From: Alison Crabb [redacted]
Sent: 05 September 2017 10:42
To: Planning.Responses
Subject: RE: Planning Consultation on: BN/28/17/RES

APPLICATION NO: BN/28/17/RES

Site Address: Land R/O Lillies Yapton Road Barnham PO22 0AY

Description of Works: Approval of reserved matters following outline consent
BN/32/15/OUT relating to appearance, landscaping, layout & scale
for erection of 38 No. dwellings including open space, landscaping &
new access

APPENDIX C

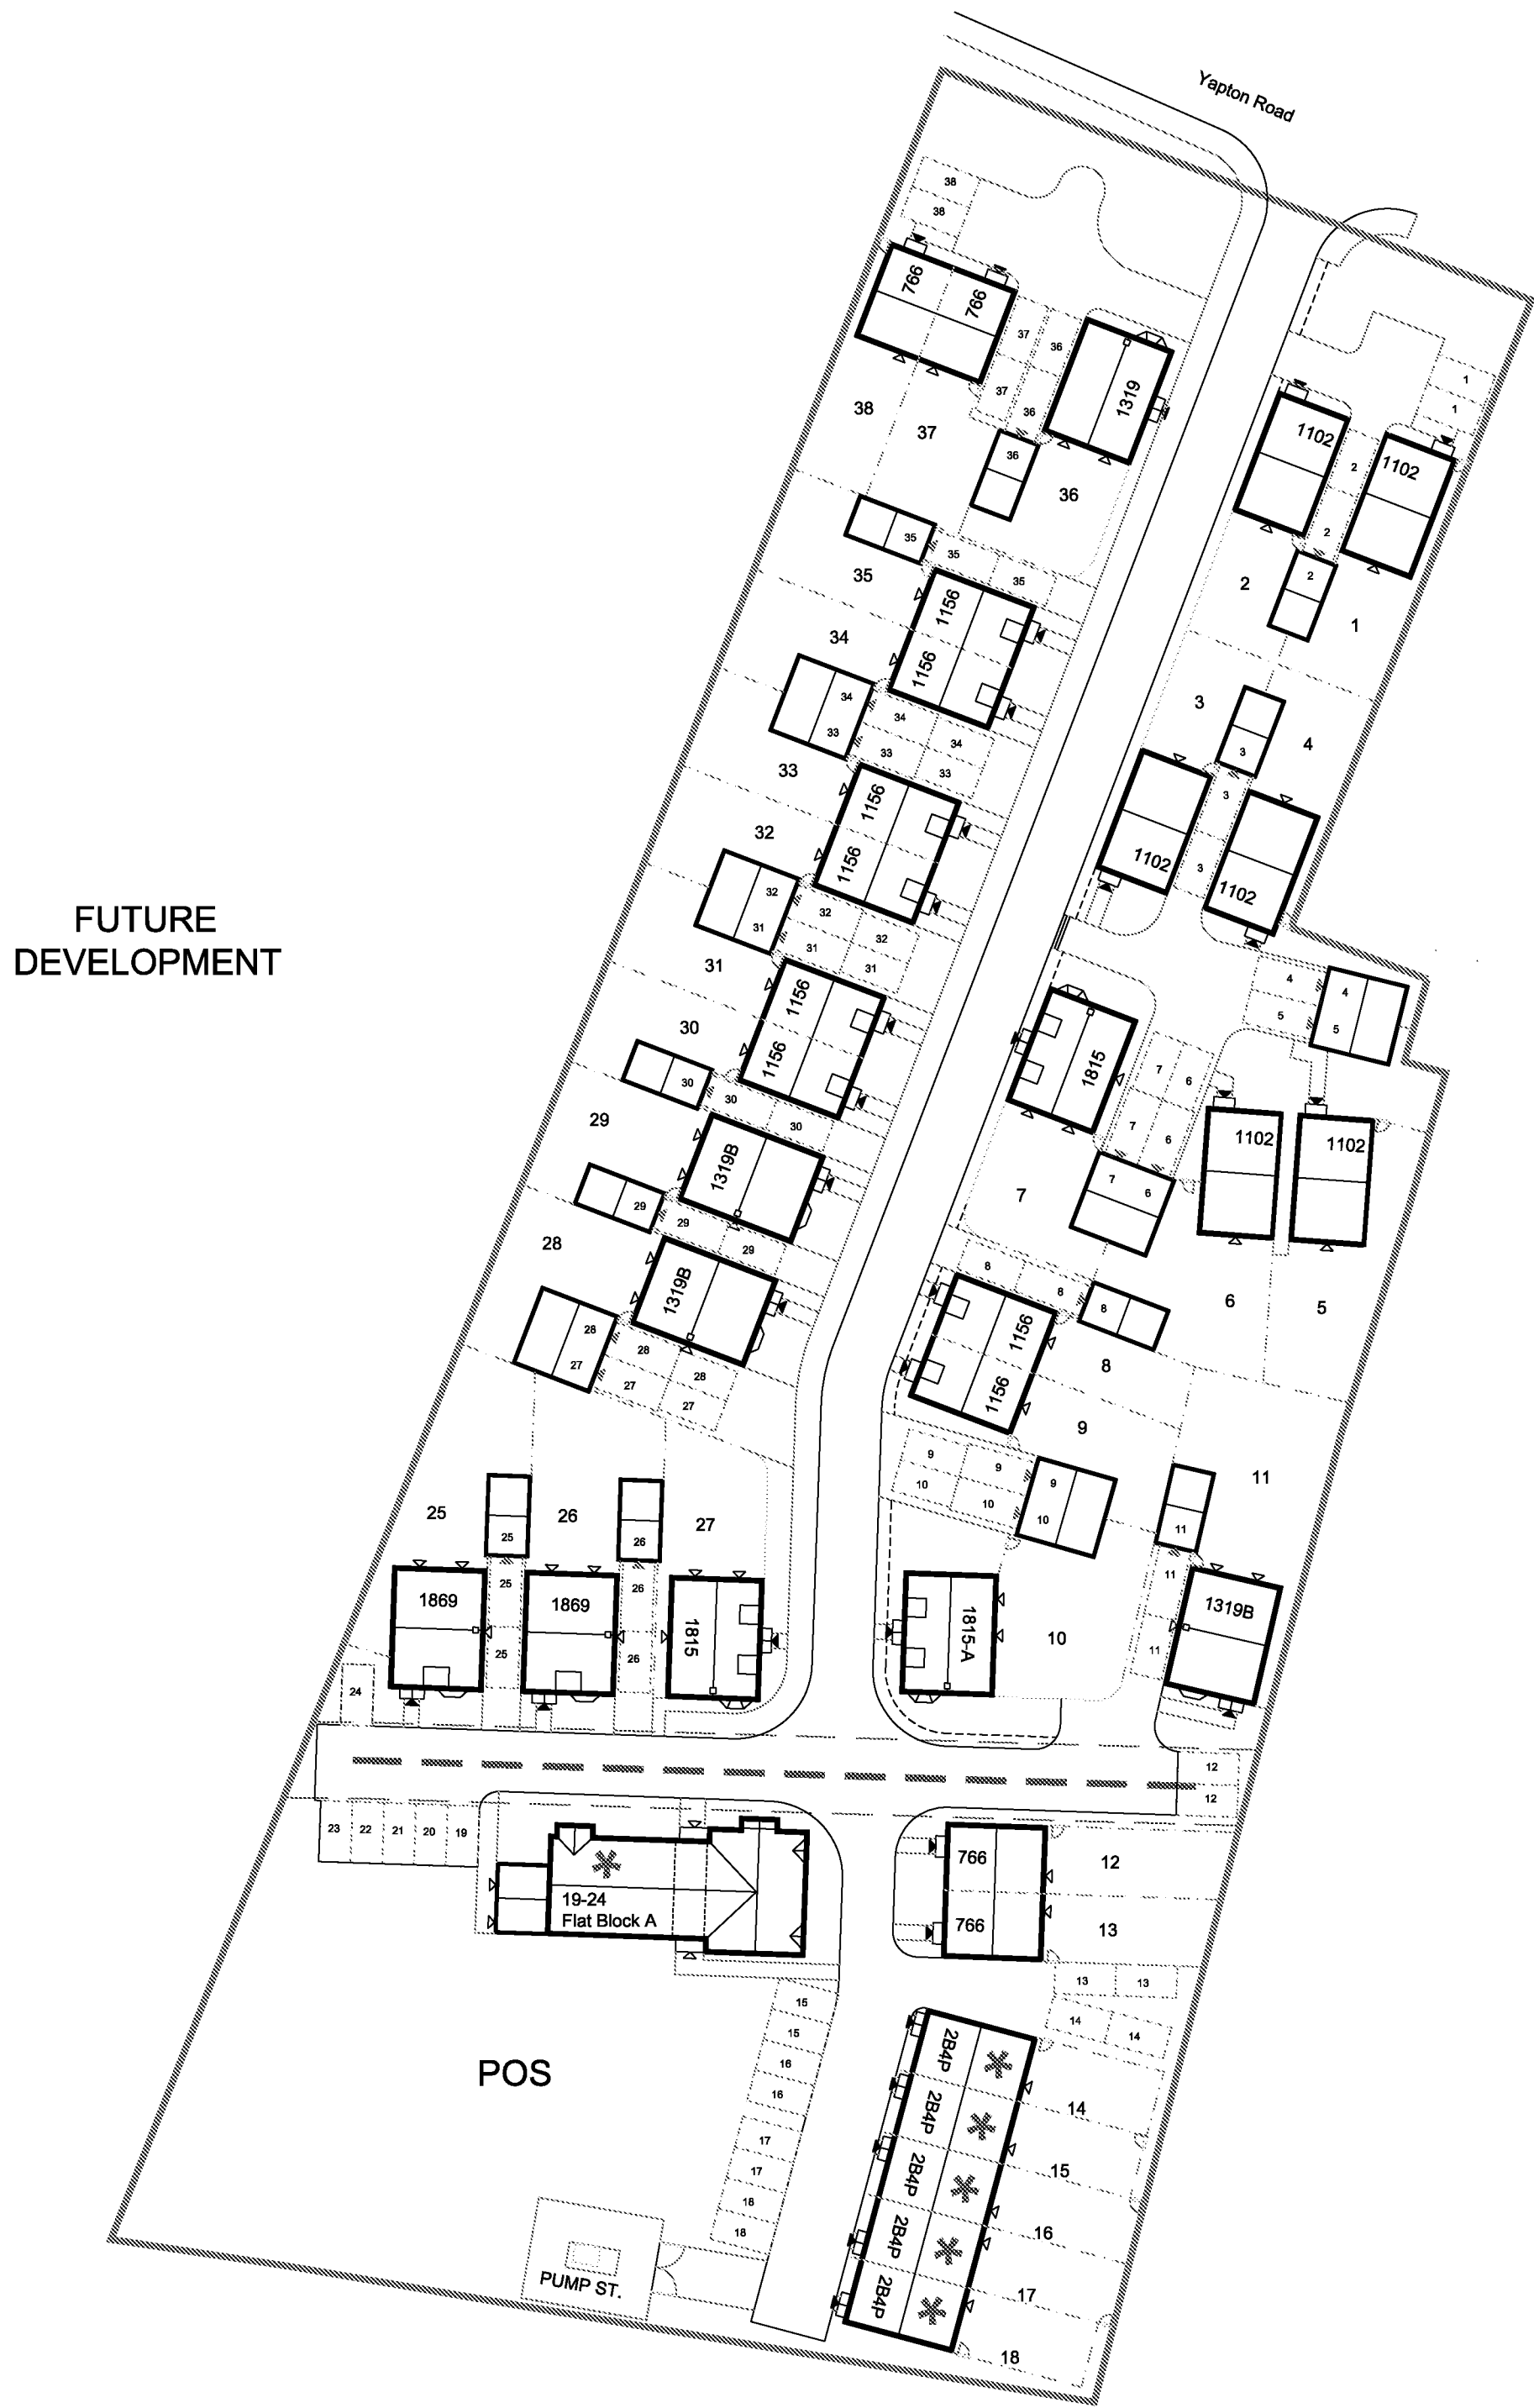
The plans as submitted show no connection to the land known as Angel's Nursery which was agreed in the original planning application and the Council feel that that this should be reinstated to enable residents to safely access the local amenities provided at Murrell's Field and Barnham Community Hall.

Finally the proposed position of the flats shown on the plans is too close to the watercourse. The Council understand there is a certain distance that they must be away from the watercourse and that is not the case with the stated position.

APPENDIX D

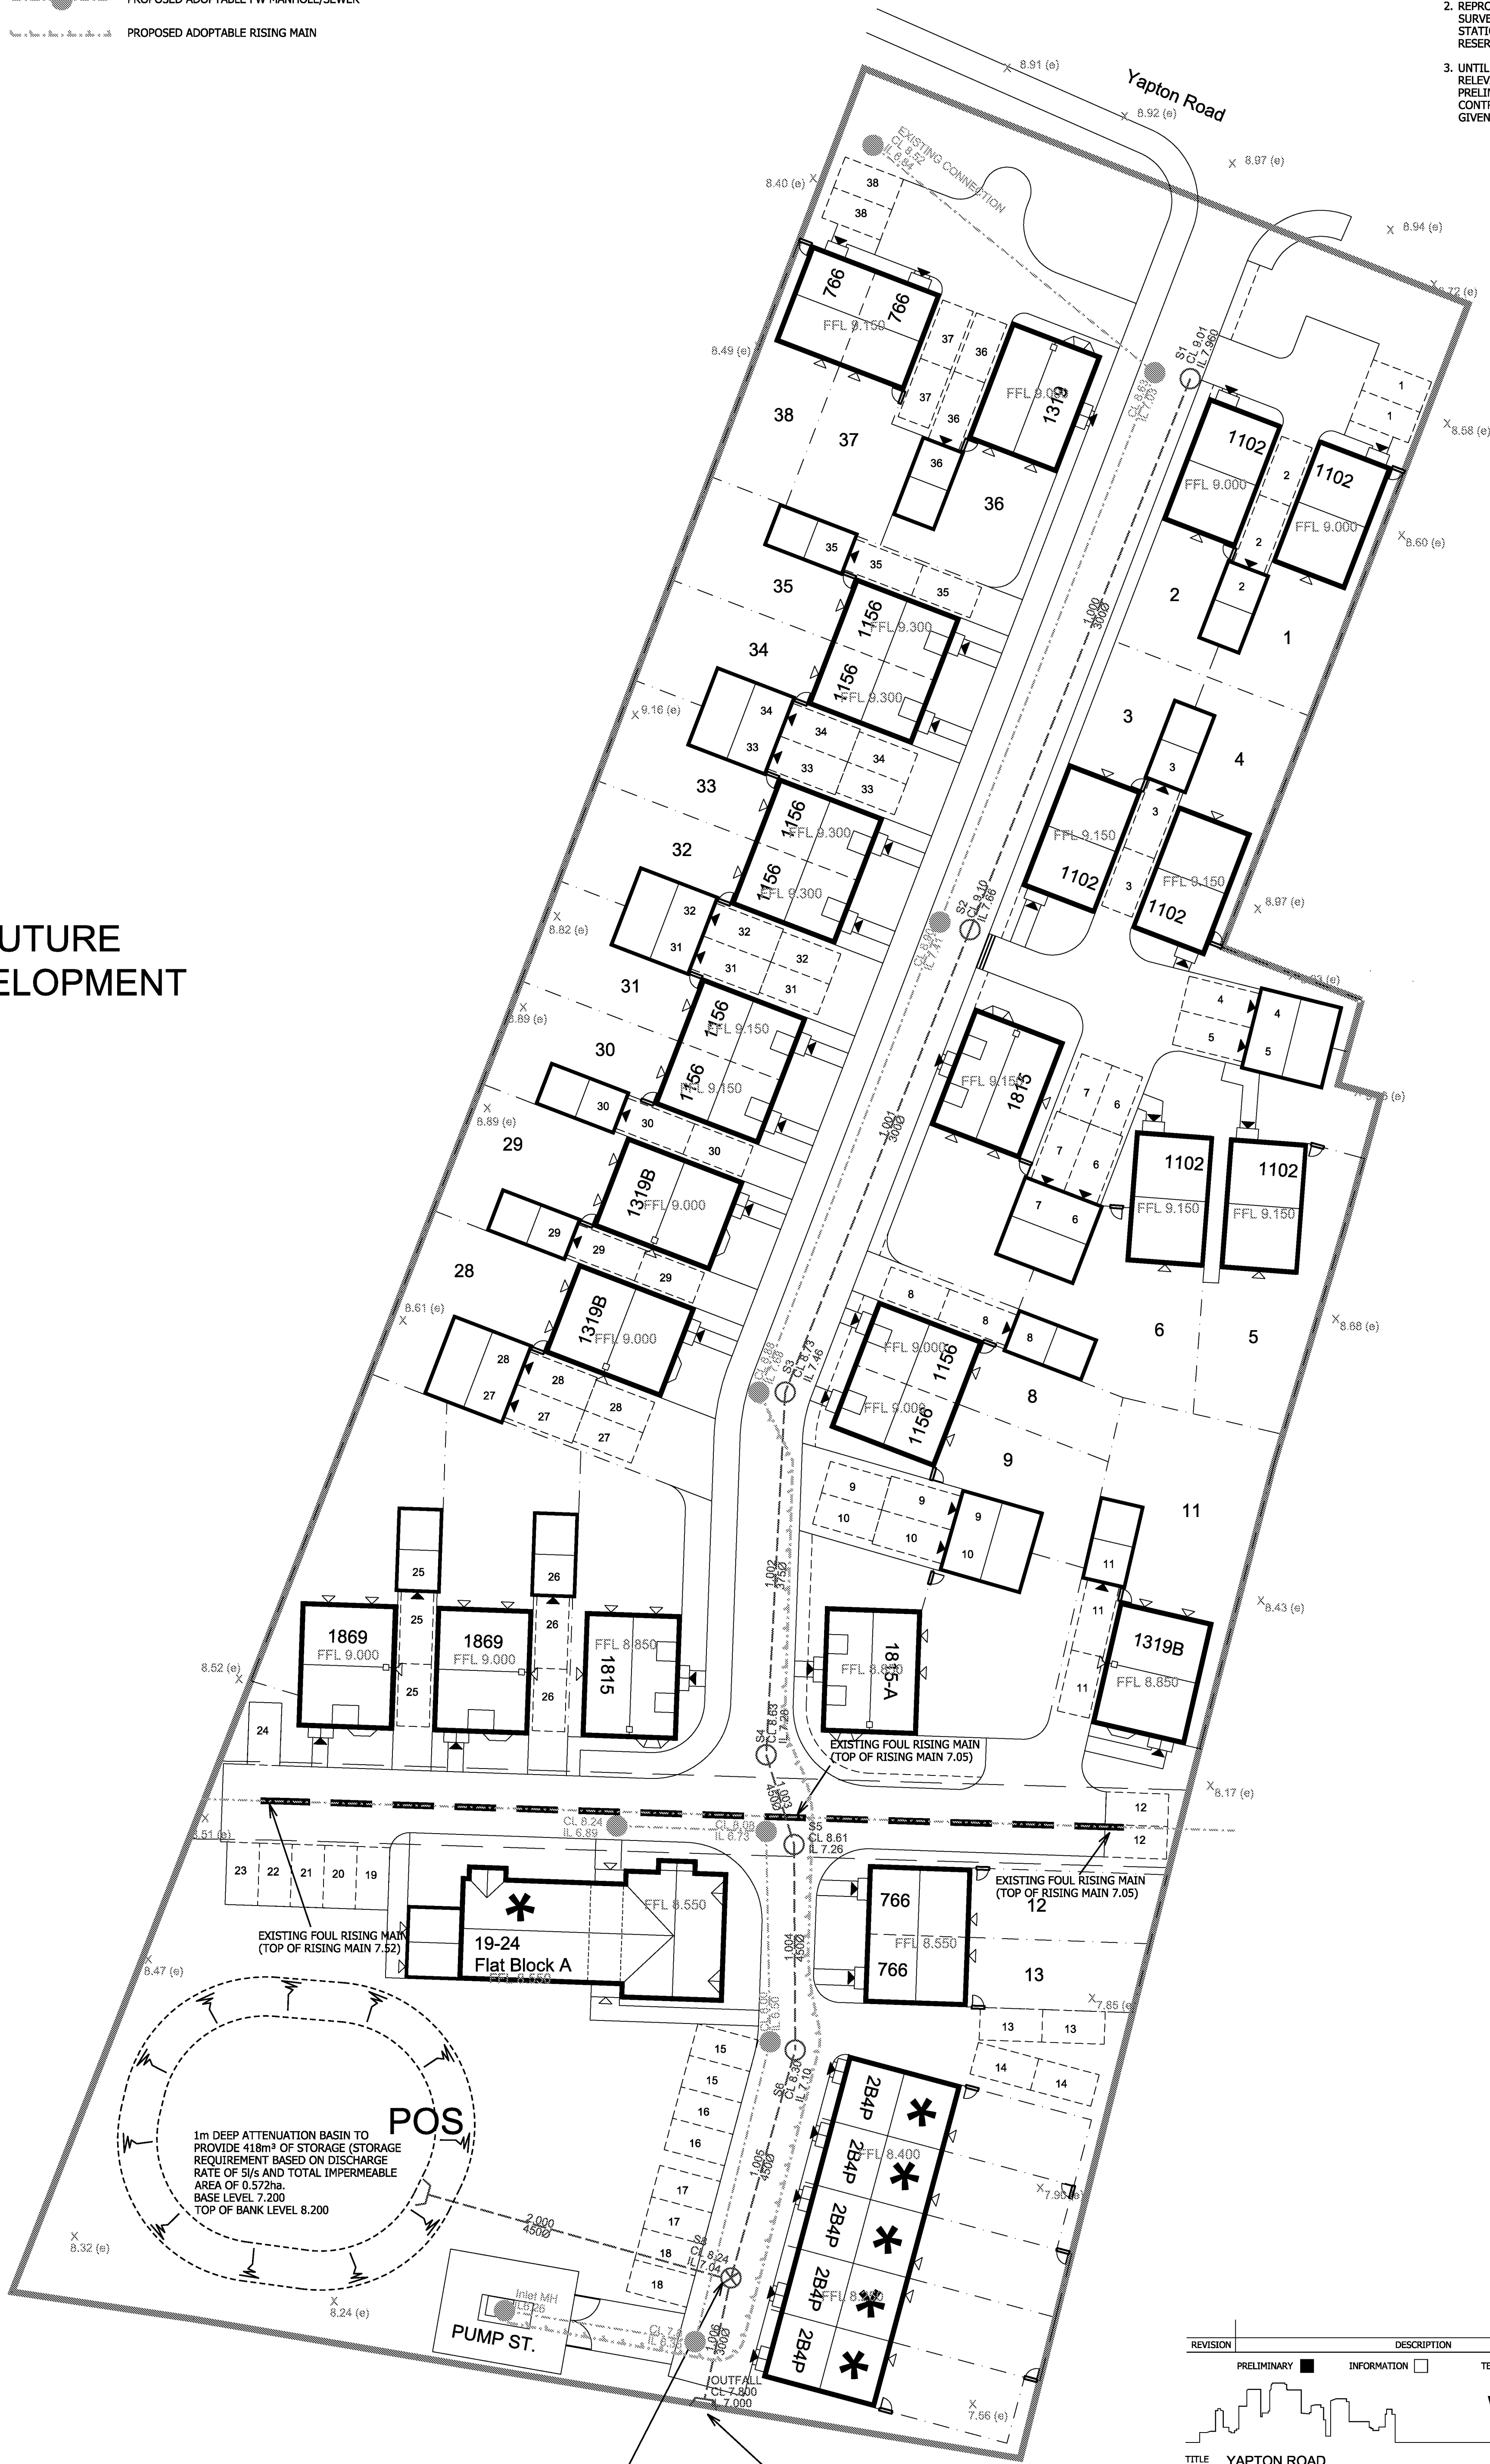
The Council believe the siting of the pumping station needs reconsidering as it is far too close to the watercourse/ditch into which the builders want to run their surface water. (We also believe the developers of Angel's Nursery wish to do the same thing).

The watercourse is very overgrown and would need to be properly cleared and engineered to enable water to flow freely as if both these developments do send surface water into the watercourse in its present condition it would be unable to cope and flooding issues would occur.
